Application H15-0014-22
Location Land adj. to Crossroads Nurseries Main Road Quadring PE11 4PJ
Proposal Erection of 61 dwellings & associated works

Name Ian Marshman - Historic Environment Officer
Address Historic Environment Officer Lincolnshire County Council Lancaster House LN1 1XX

Date Submitted 25-03-22
For/Against Comments

DRAWING TITLE
Proposed Block Plan

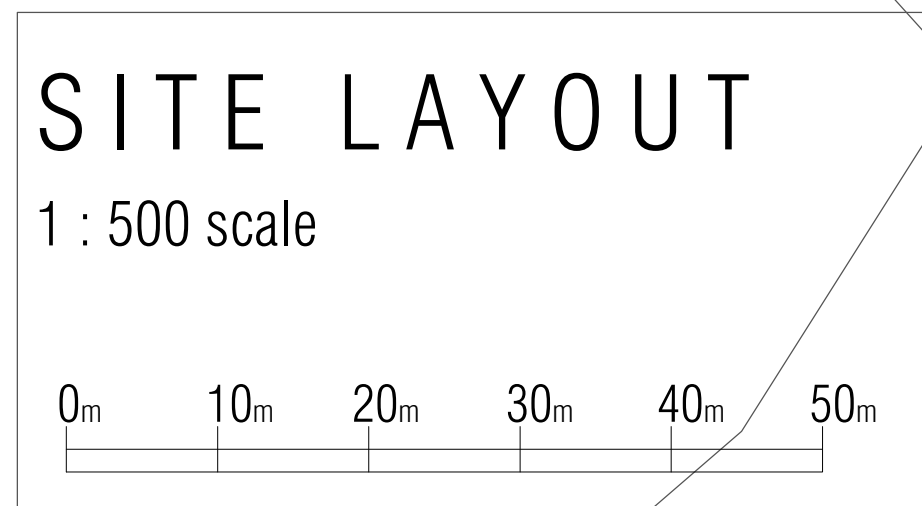
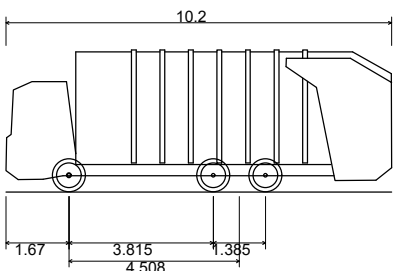
In order to preserve the most significant remains 'in situ' and avoid impacts from development or the need to excavate them, it was agreed with the developer that the areas around Trench 5 and Trench 4 should be located within the proposed public open space. This is in accordance with Section 16 of the NPPF and Policy 29 of the South East Lincolnshire Local Plan which seeks to avoid and minimise potential impacts on heritage assets.

It is also recommended that a separate condition be added to the grant of any permission to require the fencing of the area of the proposed public open space during construction in order to ensure that the remains intended to be protected can be successfully 'preserved in situ' throughout the construction process. The fencing should include signage identifying it as an area of archaeological importance, and that it must not to be used for excavation, dumping of spoil, or storage of plant etc. with any variation approved in writing by the local planning authority.
